11 August 2022

Pre-application Advice

HELMINGHAM HALL, SUFFOLK – WORKS TO THE HALL

<b>Ben Pentreath</b>		3 Lamp Office Court Lamb Conduit Street London WC1N 3NF T +44 (0) 20 7430 2424 benpentreath.com
PROJECT:	HELMINGHAM HALL	
TITLE:	PROPOSED KITCHEN WINDOW DOOR	
DRAWING NO: A-101.4	REV. NO: -	
SCALE: 1:10@A1 1:20@A3	DRAWN BY: PWD	
DATE: 02.11.22	CHECKED BY: RJC

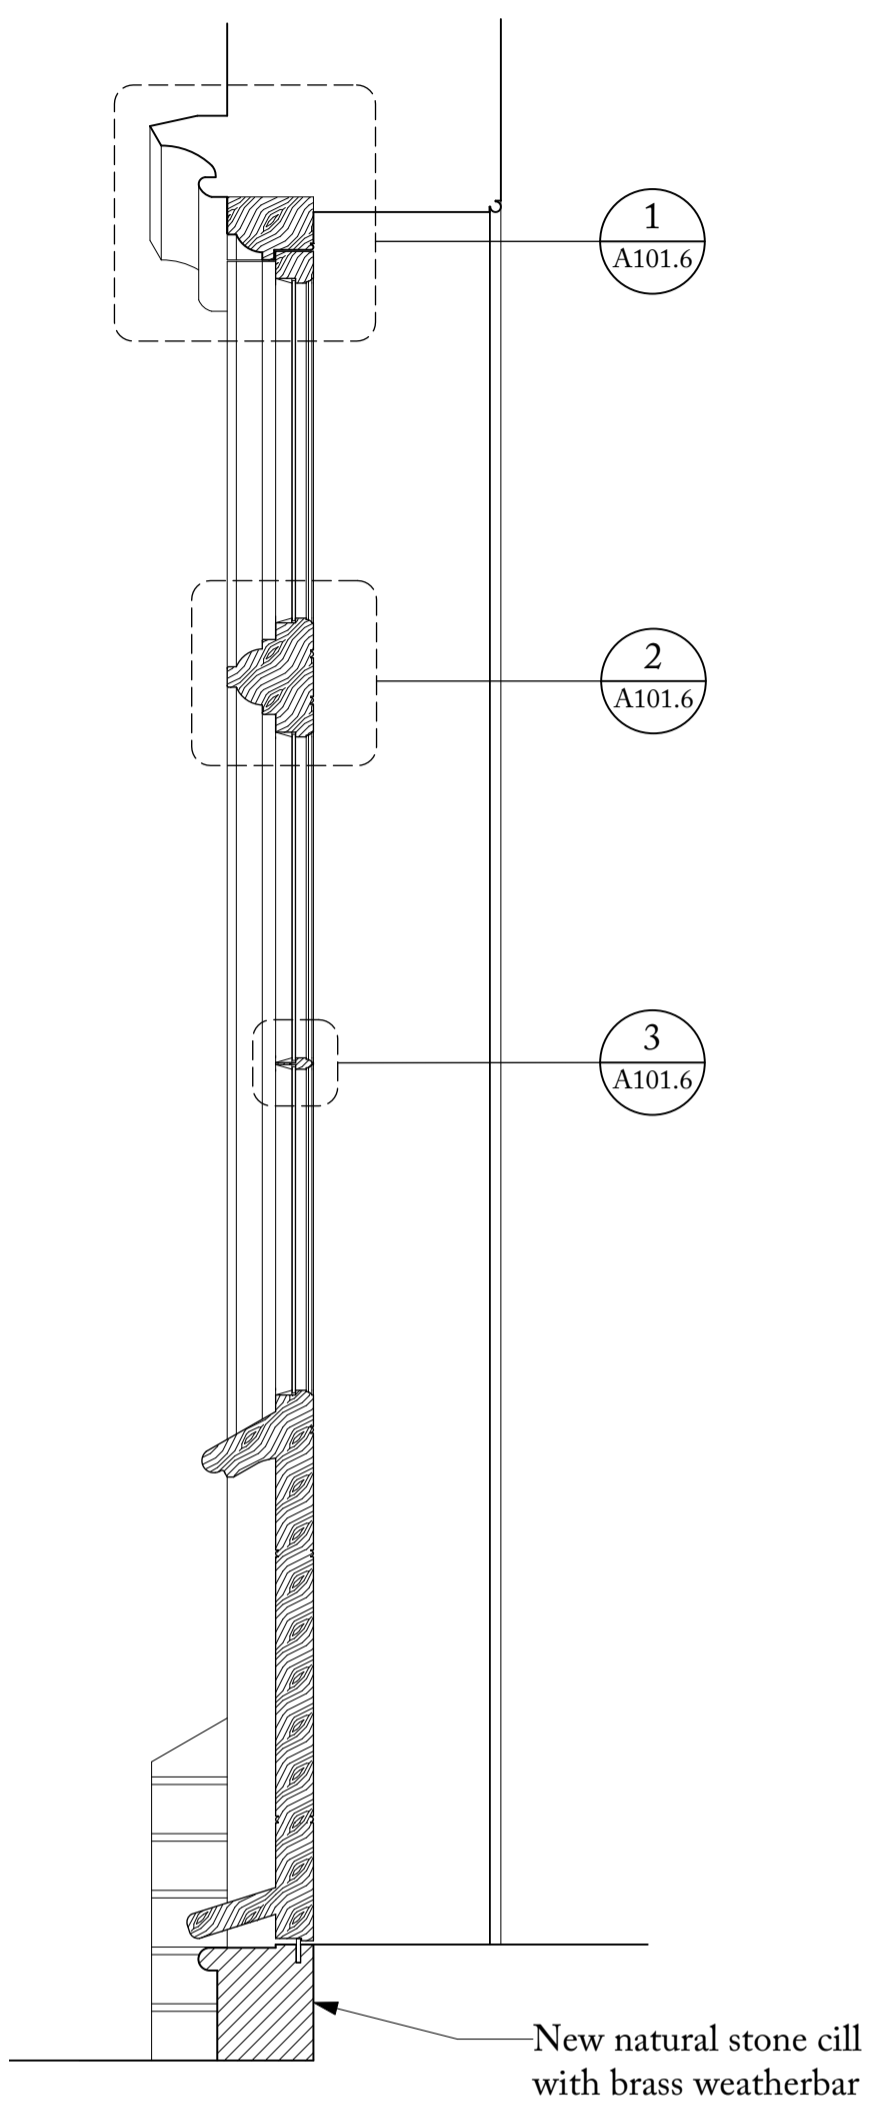
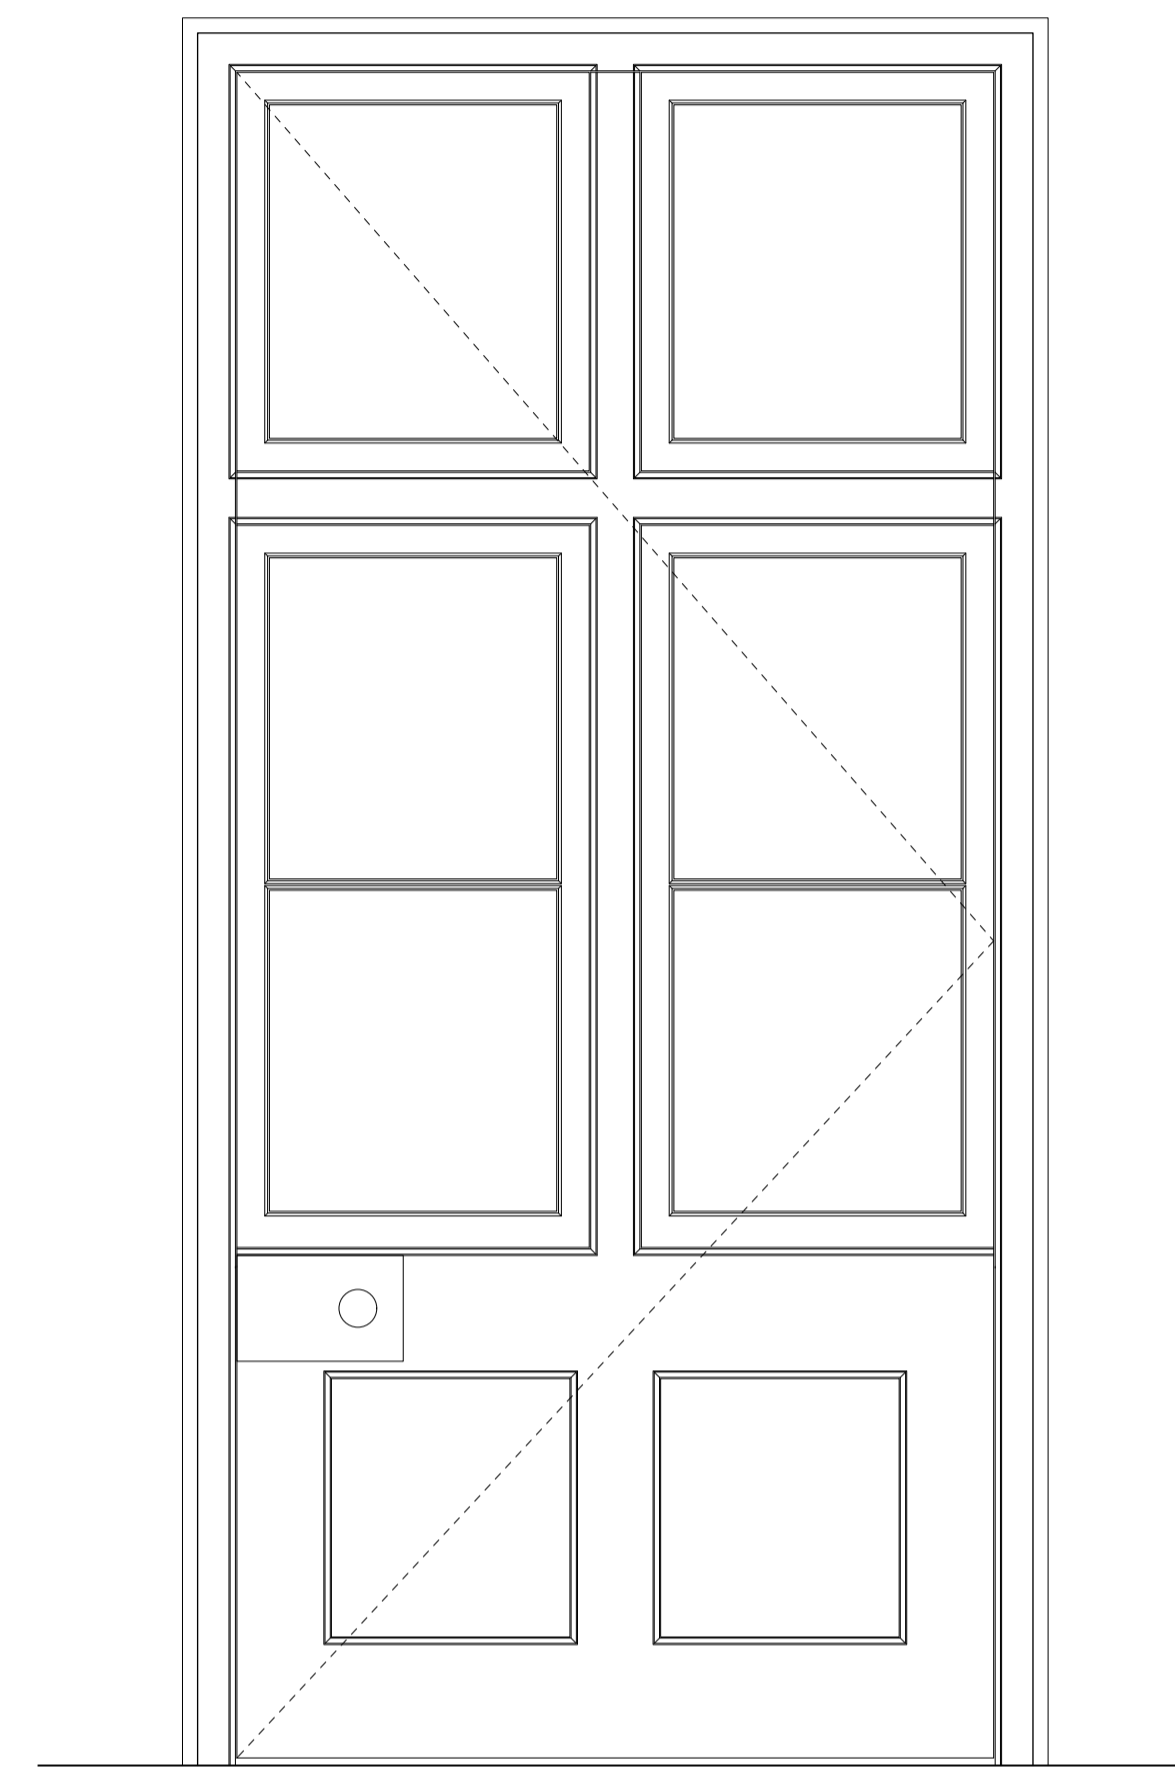
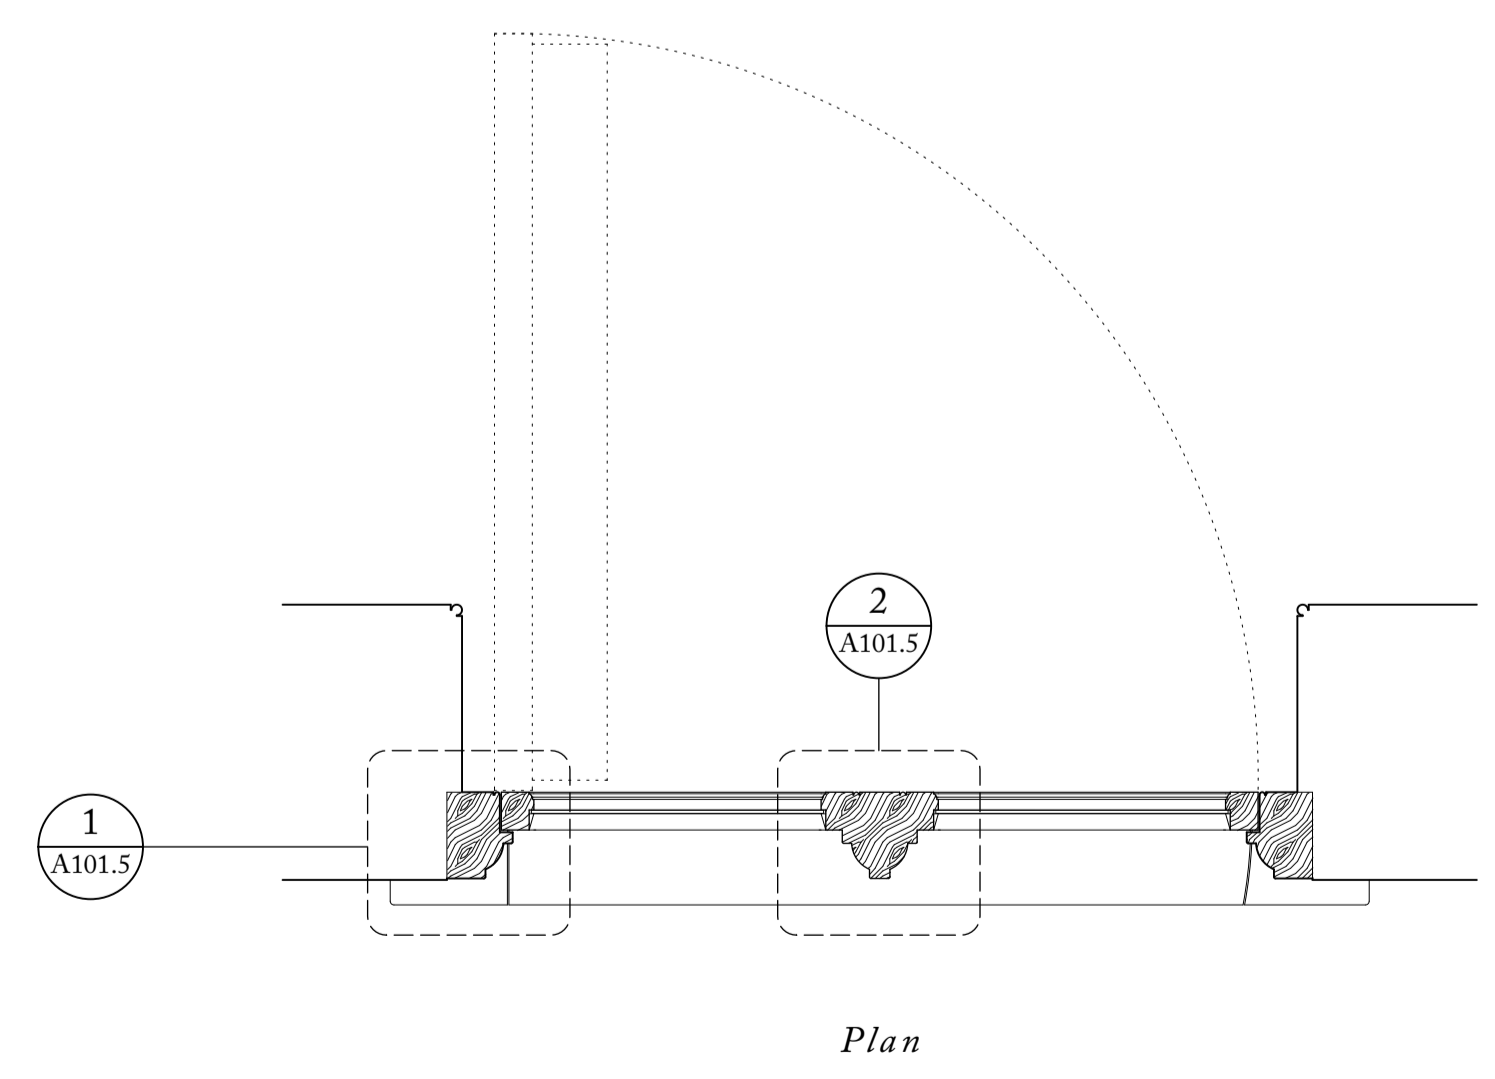
The opening up of blind windows, the conversion of one window to a door to match an existing door on the southern elevation and secondary glazing on the upper tier of windows would not, in principle, detrimentally alter the visual character of the building from this important public facing elevation. Although the conversion of a window to a door would result in some loss of historic fabric at the base of the door, this is considered to be minimal. The works are proposing to reuse the original window and existing mullions however, the section drawing shown seems to be showing double glazing and slightly thicker profile glazing bars. This needs to be reviewed as when compared with other windows in the run at this point, it could be noticeable. On the elevation drawings provided the lines are darker but this could just be drafting. Drawings for the ground floor windows should also be provided at application and we suggest that single glazing should be used.

Historic England are broadly supportive of the proposals presented in this pre-application submission. We consider that, subject to details and confirmation of the glazing in the new door to the kitchen your proposals could be ones to which we would not object.

TITLE: PROPOSED GROUND FLOOR M&E

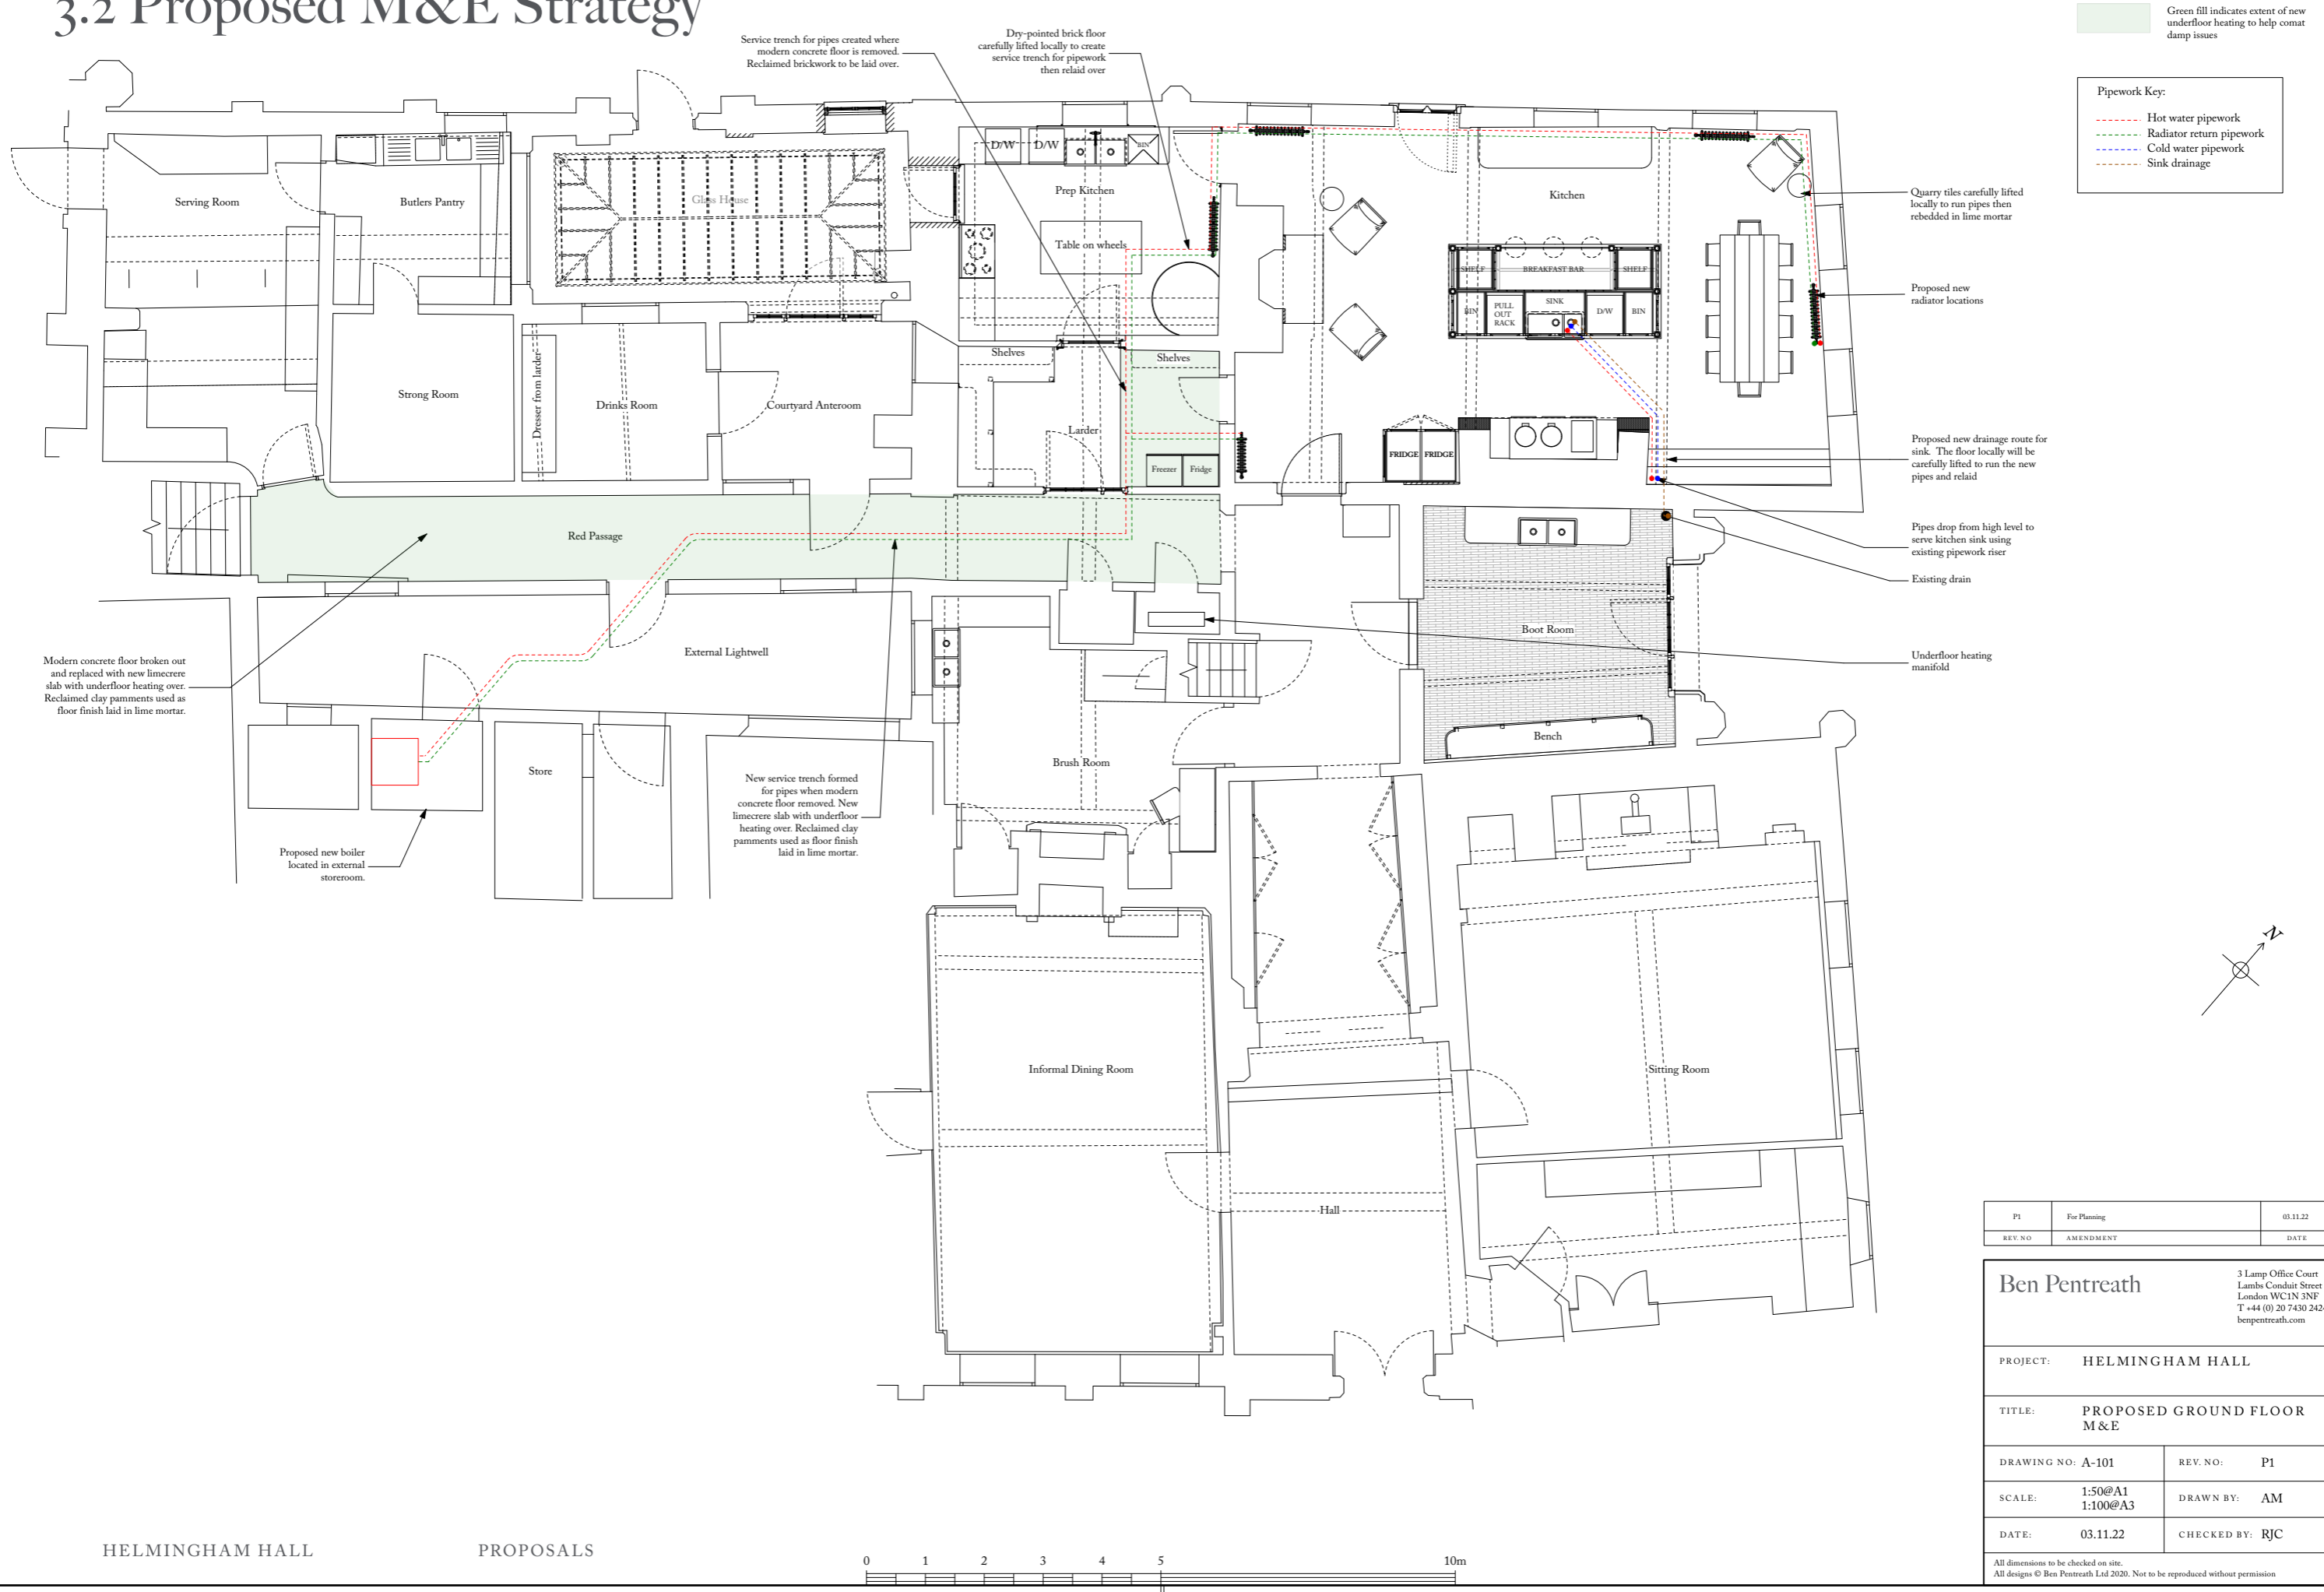
The internal changes would not result in harm to the significance of the building. The installation of underfloor heating has not been discussed at any length as these discussions were focussed in other areas and consideration will need to be given to whether this would raise the floor level and cause alterations to be required in other places. I would be happy to discuss this with you at another point if this would be useful.
